From: Stephen Gee [REDACTED]
Sent: 28 September 2021 14:52
To: Juan Baeza <Juan.Baeza@arun.gov.uk>
Cc: Donna Trethewey [REDACTED]
Subject: RE: A/26/21/RES If you have any comments

Thank you again for the updated documents regarding planning application A/26/21/RES.

Further to my responses to the above planning application, it has been brought to my attention that the developer is planning on making Public Right of Way, Footpath 2159 into a cycleway, as per the attached drawing.

2. Site Analysis
Site Access / Connectivity

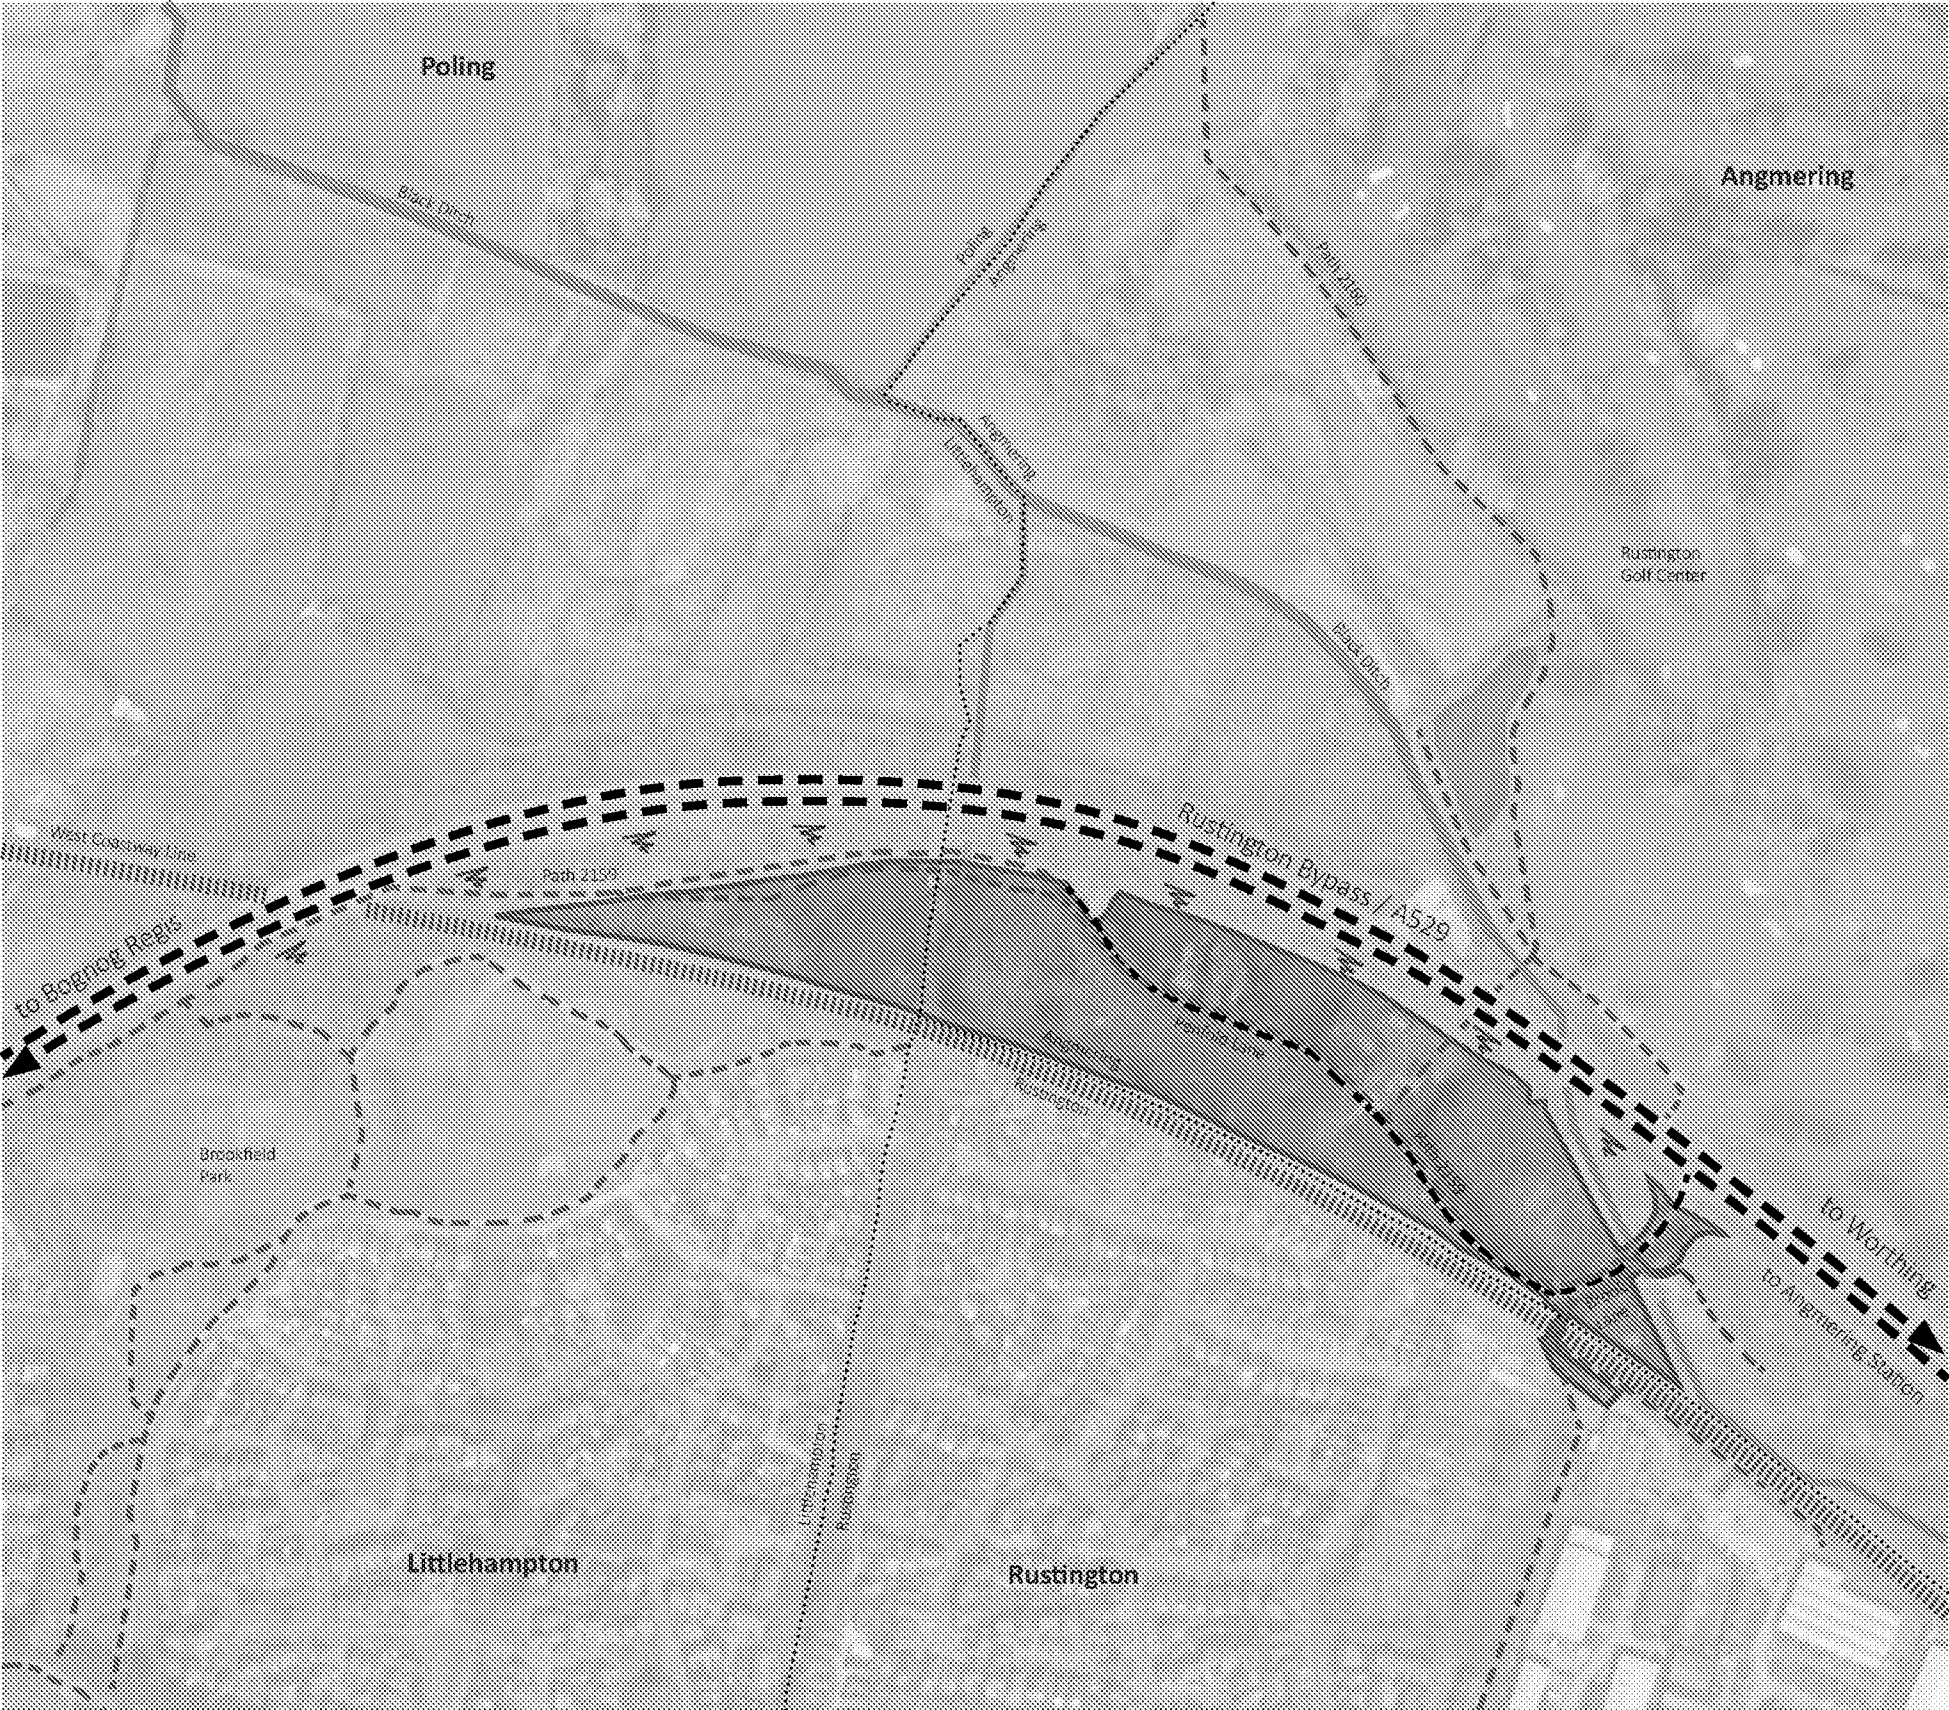
In response, whilst cycles are allowed on the section of Public Right of Way FP2159 that is being urbanised into a road, from the point where the developer proposes to install bollards to prevent vehicular use,

- 1) we would need to approve these bollards, we would need to see a demonstrable need for their installation and approve the design,

- 2) cyclists are not allowed to proceed along the footpath without permissive cycle rights being given under agreement by the landowner.

I note also that to the west of the development, the developer has indicated that their internal cycle path will join with FP2159 outside their red line boundary.

Again, any cyclists that have cycled through the green area along the developer's cycle route will have to dismount once more without the same permissive cycle rights being given by the landowner. Does the developer have control over the land at this point to give permission? We obviously can't enter into any permissive agreement on land outside their control.

We appreciate the developer's desire to promote sustainable and active travel modes however, with no ability to continue cycling along FP2159 in either direction outside of the developer's red line boundary, there is no sense in allowing cyclists to use FP2159 so little incentive to enter into any permissive agreement along any of it. The section

- How will cyclists rejoin the caridgeway/enter the cycle route? I note the applicant suggests signage could be used but for such a short section I doubt this would be effective. A consistent approach through the site would be much more desirable.
- What measures would restrict motor vehicles utilising the western section?

Can the developer please be asked how they plan on allowing cycles along the footpath, particularly through the open space / green area? This is not permitted without the footpath being upgraded to a bridleway, which has consequences for the bridge they are planning over the railway, or the landowner giving permissive rights.
